Please ask for: Mrs D Johnson
Email: daun.johnson@arun.gov.uk
Telephone: 01903 737762
Our Ref: A/151/20/OUT
Your Ref:
Date: 14th September 2020

Application for Outline Planning Permission

Development: Outline application for all matters reserved for the erection of 1 No. detached dwelling with associated landscaping and parking.
Location: Land To The South Of Downes Way (North Of 15 Ambersham Cresc Downes Way Little Hampton BN16 1AA

Block Plan 1:2500 at A4 DRAWING 001

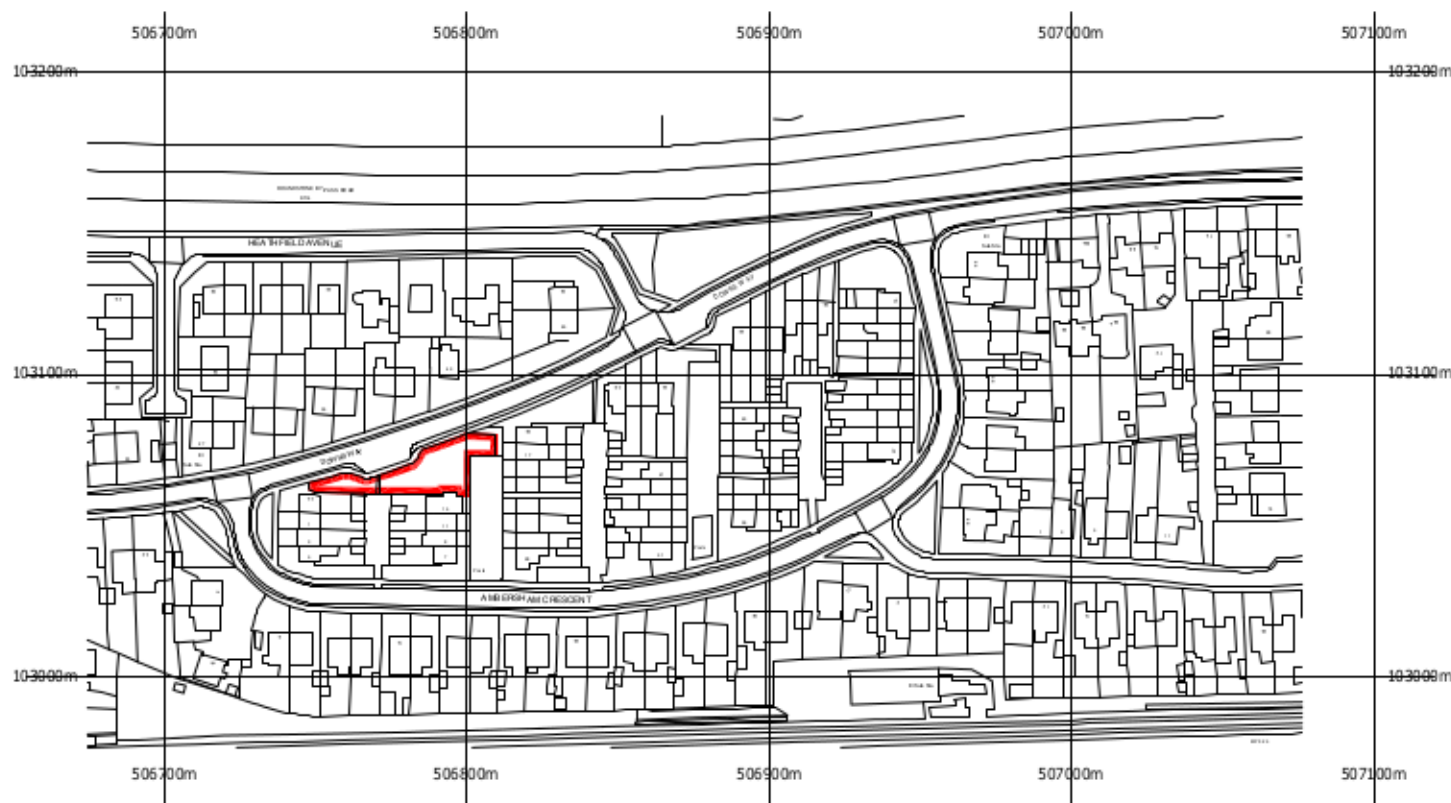
Block Plan

Please submit 1 electronic or 3 paper copies of a block plan at a scale of 1:500. Further details of what must be included on the plan can be found in the Validation Requirements List. Please indicate the proposed access to the site and include visibility splays on this plan .
